From: Graham Evans
Sent: 10 January 2014 14:52
To: Planning.Responses
Subject: FW: Planning Consultation on: BR/318/13/

APPLICATION BR/318/13/

Site Address: Rear of 13 and 15 Richmond Avenue Bognor Regis PO21 2YE

Grid Reference: 92518 98980
Description of Works: Placement of Biomass cabin and pellet store to rear garden including pipework.

ABBEYFIELD CARE HOME BIOMASS INSTALLATION

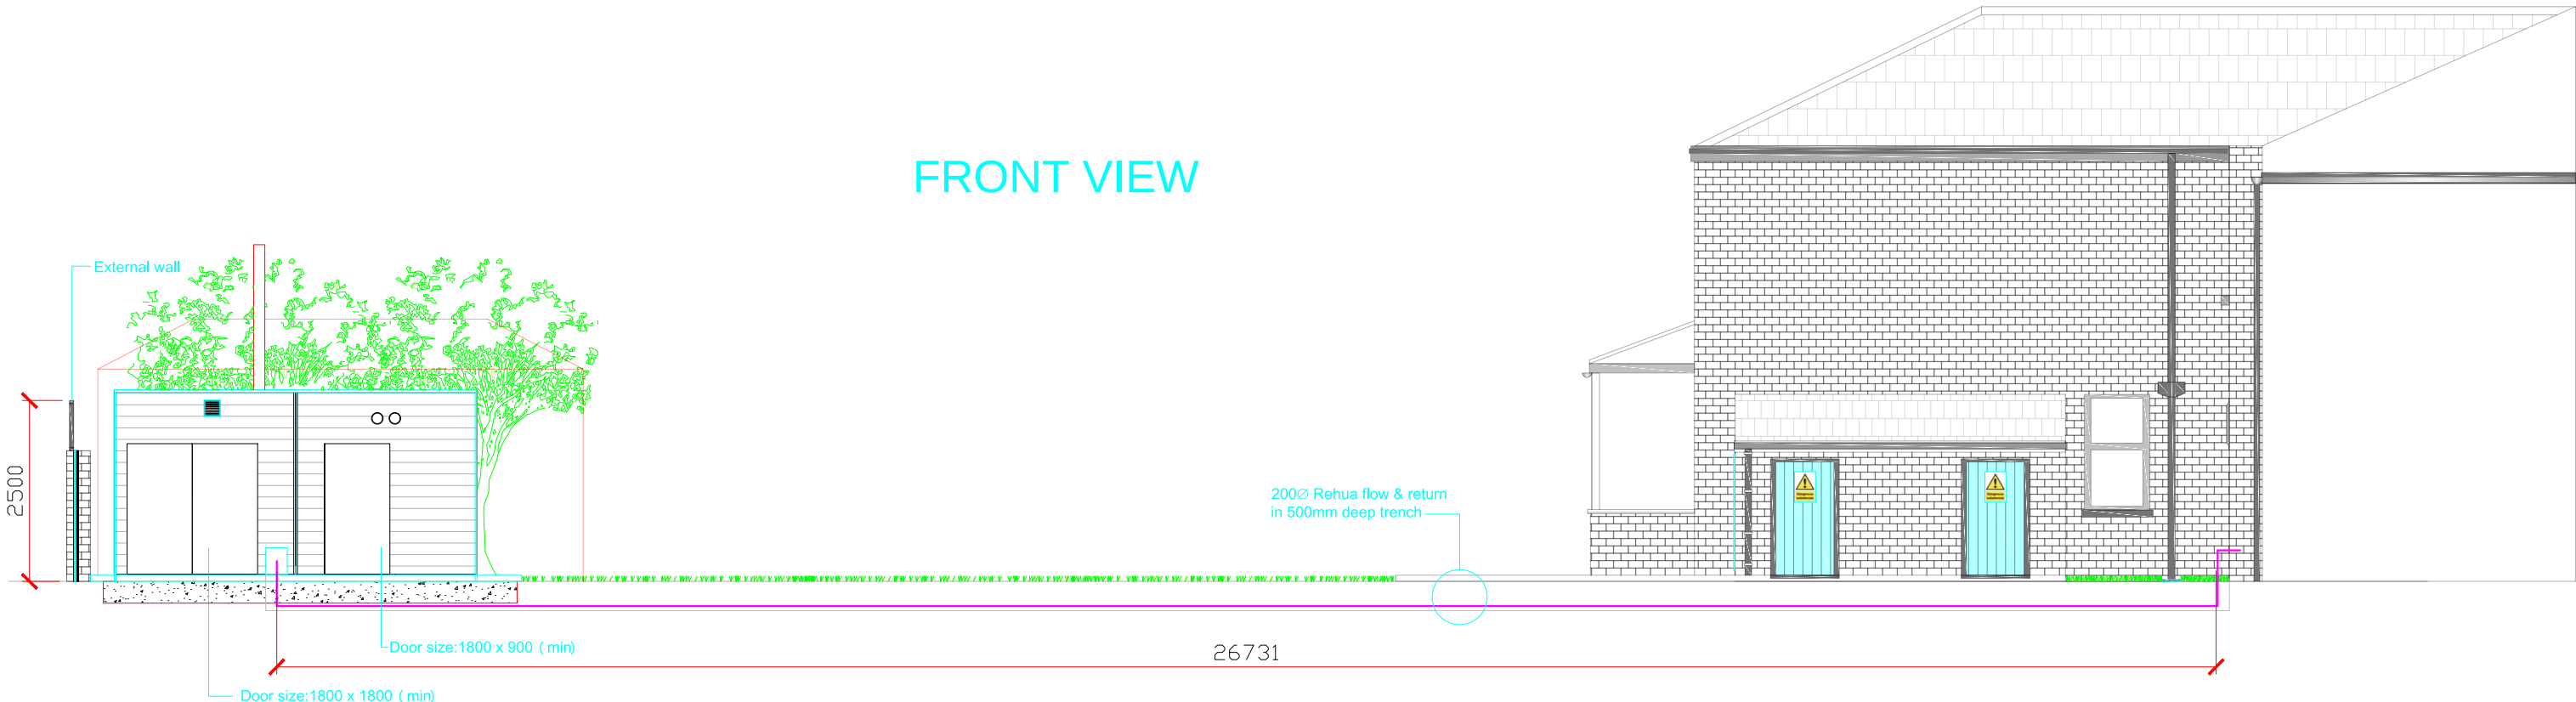
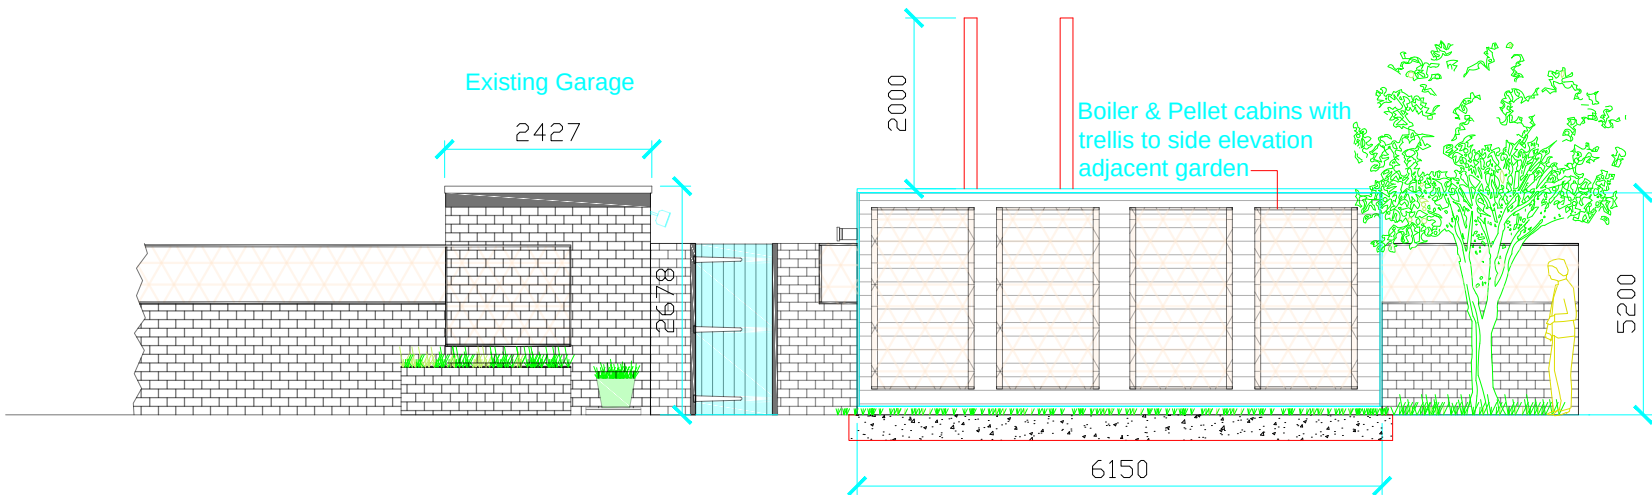
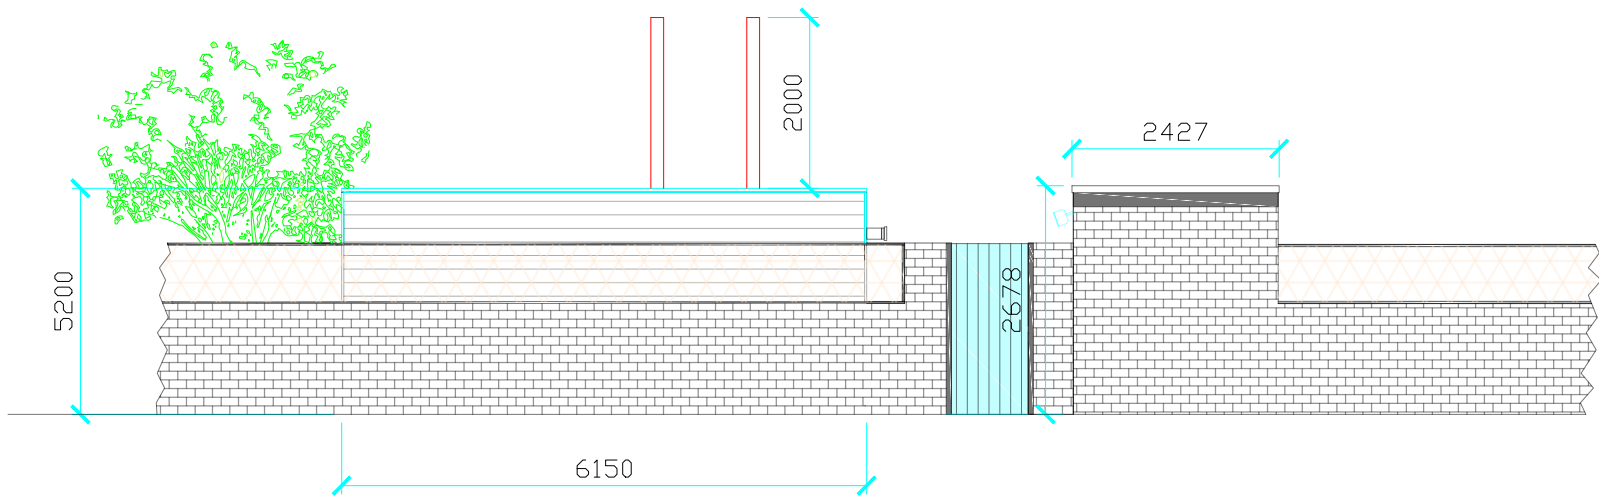
I note that the application includes the installation of 2X90kw biomass boilers served by a single chimney terminating 2m above roof height.

As the boilers are situated in an urban area an air quality assessment should be required (see attached Air Quality Guidance and Local Air Quality Management Technical Guidance LAQM.TG(09) --Chapter 5 - <http://archive.defra.gov.uk/environment/quality/air/airquality/local/guidance/documents/tech-guidance-laqm-tg-09.pdf>). The attached EPUK Guidance may also be helpful/informative.

An air quality assessment using dispersion modelling shall be carried out and submitted to the local authority to demonstrate that the stack height of the biomass boilers is sufficient to prevent emissions having a significant negative impact on the air quality objectives for nitrogen dioxide (NO₂) and particulate matter (PM₁₀). Where emissions are shown to result in an increase a full discussion of any potential breaches of air quality criteria shall be provided and an outline of how emissions will be mitigated.

S14-16 require the height of chimneys serving furnaces burning solid matter at a rate >45.4kg per hour to be approved by this Authority. In assessing the height of the chimney reference should be made to the Third Edition of the 1956 Clean Air Act Memorandum on Chimney Heights. There is an overriding minimum requirement that a chimney should terminate at least 3m above the level of any adjacent area to which there is general access (i.e. ground level, roof areas or adjacent openable windows).
